Consultation Response from KC, Conservation & Design

2024/91707 21-23, 25 and 27 Round Ings Road, Outlane, Huddersfield, HD3 3FQ

Date Responded: 15.7.2024

title Bifold Door Details
number 23038D-07-P02
scale 1:20 and 1:2
size A2

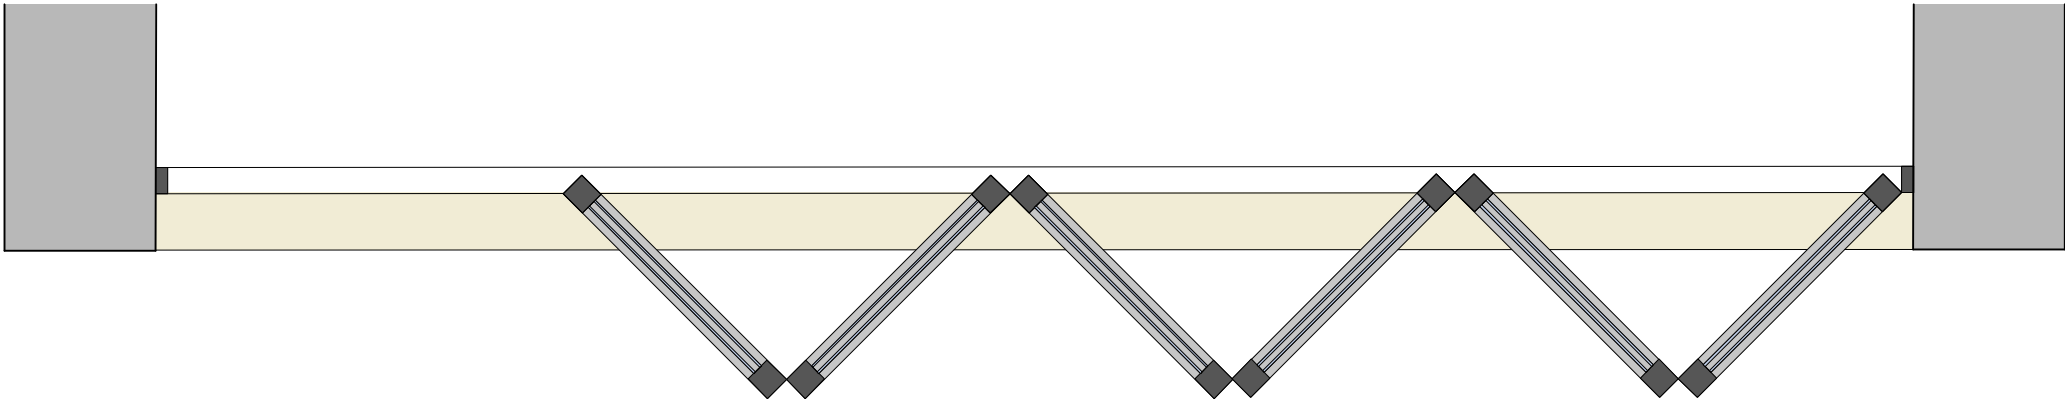
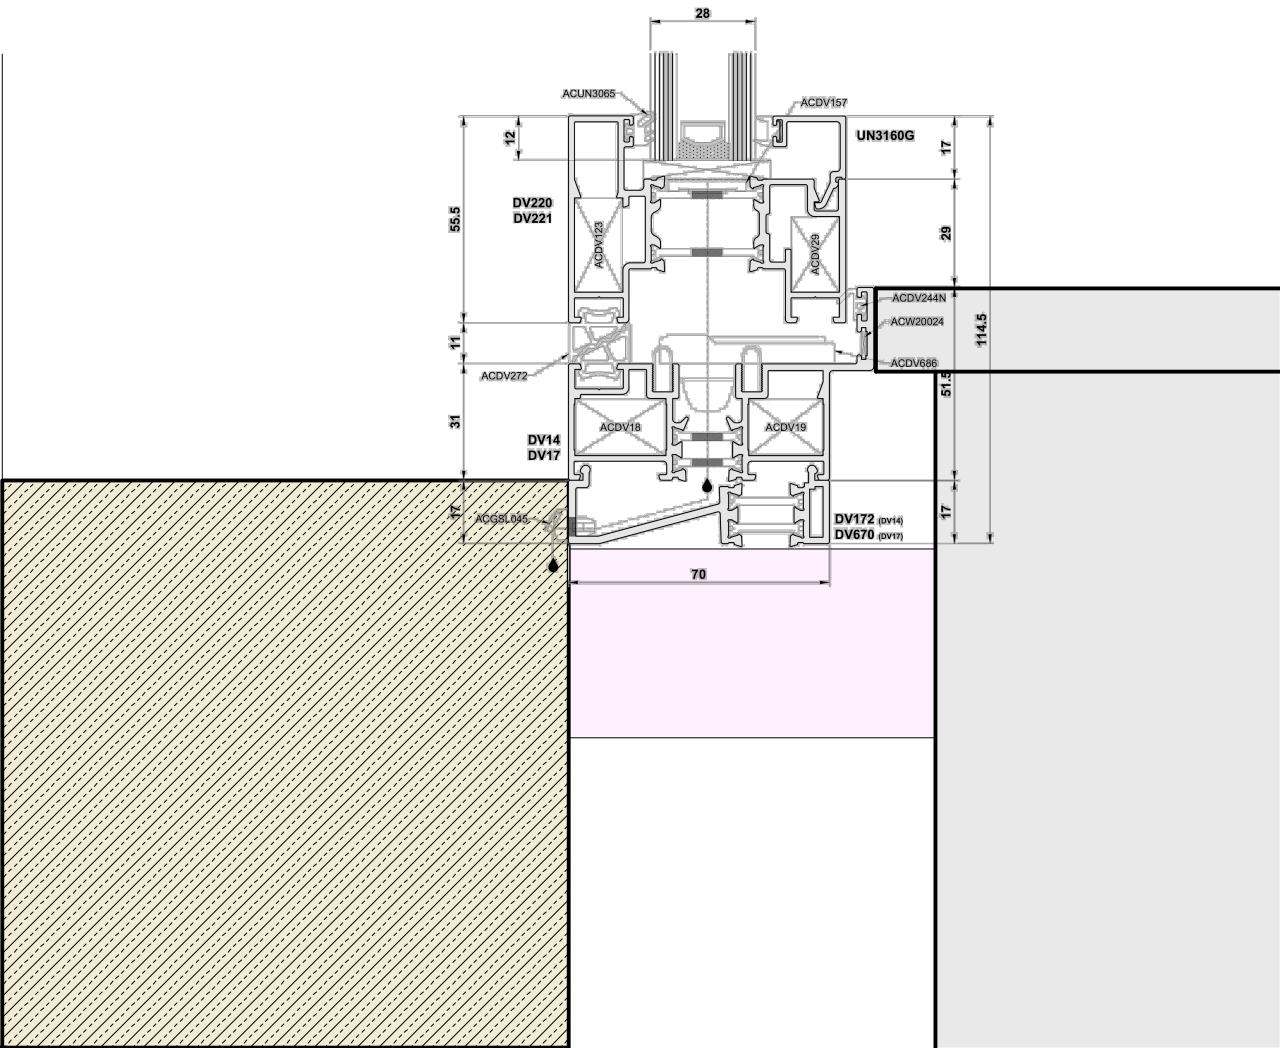
A drawing and specification of aluminium bi-fold doors has been submitted and is acceptable to discharge this condition.
